An Coimisiún Pleanála
64 Marlborough Street
Dublin 1

Ár dTag | Our Ref.
TII26-137063

Bhur dTag | Your Ref.
PAX01.324426

RE: 10 year planning permission for the construction of an Anaerobic Digestive (AD) facility and ancillary development located in Powerstown, Milford, County Carlow.

Figure 3-18: Location for Trenchless Crossing of M9

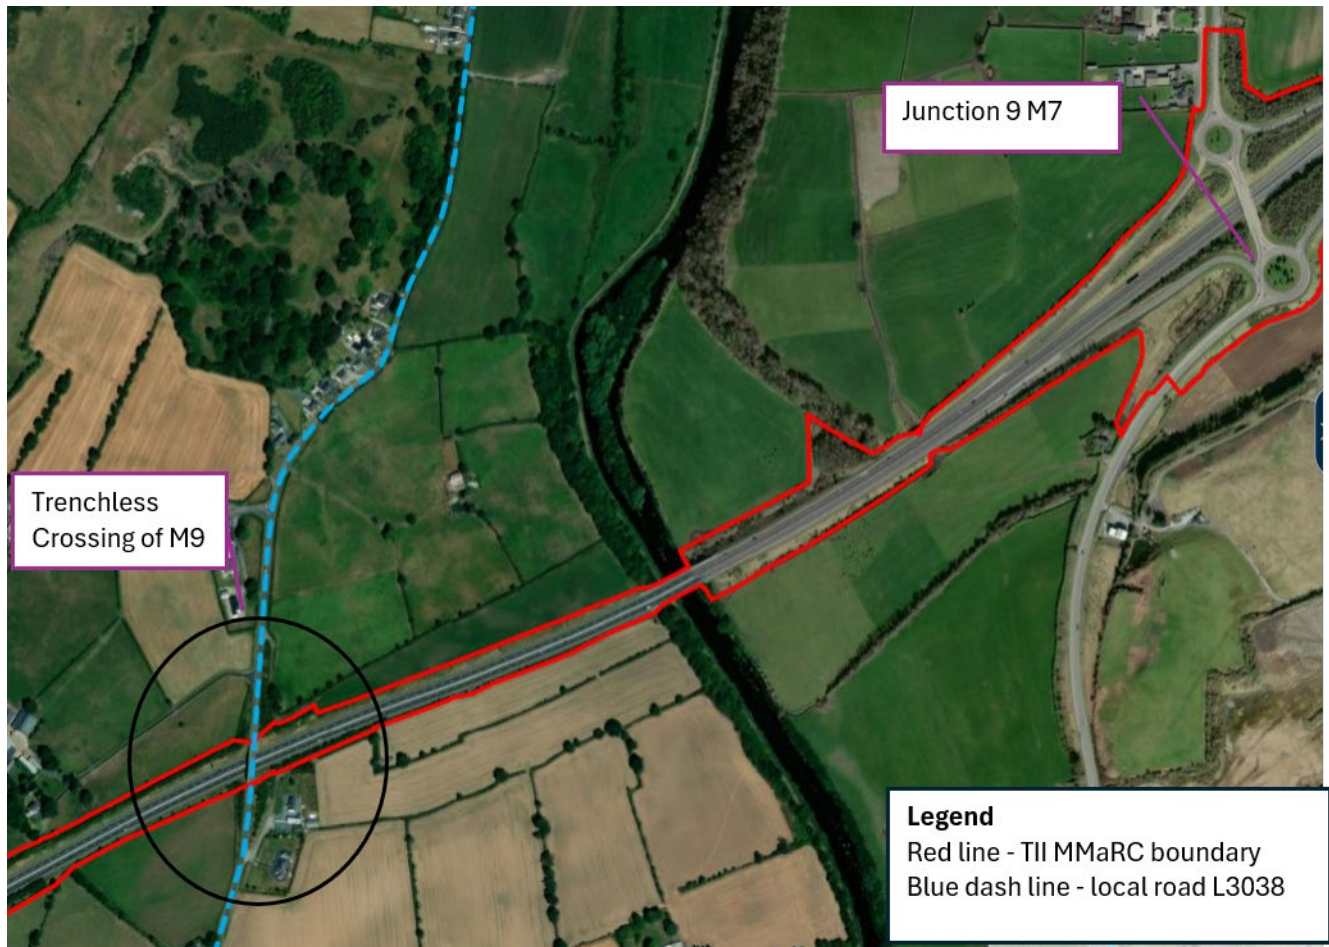
The gas network connection route indicated in the submitted EIAR indicates crossing the M9 motorway in the vicinity of an M9 overbridge (carrying the L3038) at a location part of the Motorway Maintenance and Renewals Contract (MMaRC) Network Area C. TII advises that this overbridge (Eirspan Name: *Tomard Lower Road Overbridge*, Eirspan ref. no CW-M09-012.00) is a TII Structure. TII notes the EIAR commitment at section 14.4.1 of *Chapter 14 – Material Assets* that the crossing of the M9 will be by HDD (horizontal directional drilling).

There does not appear to be a similar set of mitigation measures set out in the submitted EIAR for the HDD crossing of the M9 reflecting the technical requirements for motorway crossings as advised at pre-application consultation arranged by Carlow County Council and at EIAR scoping stage (TII ref. TII25-134184).

HDD crossing of a motorway formally engages the necessity for consent and demonstration of observance of TII Publications (Standards and Technical) and should reflect due regard for management arrangements to avoid maintenance gaps and in the interests of the safe and efficient operation of the national roads network and public safety generally. Having regard to the proposed Construction Environmental Management Plan (CEMP) supplied as Appendix 3.1 of the submitted EIAR, TII therefore recommends record and observance of the following mitigations for the proposed gas network connection route HDD M9 crossing part of this project:

- Any consent forthcoming from this application shall not approve nor imply consent for any works within the M9 Motorway reservation.
- Consent for any works within the M9 Motorway reservation, including the proposed HDD crossing, shall be required to be achieved under Section 53 of the Roads Act 1993, as amended.

- Prior to commencement of development, the Construction Environmental Management Plan (CEMP) shall be submitted for the written agreement of the planning authority subject to the written agreement of TII. The Construction Environmental Management Plan (CEMP) shall include the following commitments in relation to trenchless underground crossing of the M9:-

- a) a pre-construction survey along the length of the crossing over the extents of the motorway/dual carriageway boundary;
 - b) a commitment to and methodology for, the preparation and submission of, a post-construction survey along the length of the crossing over the extents of the motorway boundary;

- c) a record of consultation with the Motorway Maintenance and Renewals Contract (MMaRC) Network C Contractors, via TII and the relevant road authority;
- d) record of works specific indemnities, Section 53 consent and arrangements for third party access as arise following consultation with thirdpartyworks@tii.ie; and
- e) details demonstrating compliance of works on, or in the vicinity of the national road with TII Publications, including TII Publication (Standard) CC-PAV-04007 - *Requirements for the Reinstatement of Openings in National Roads*.
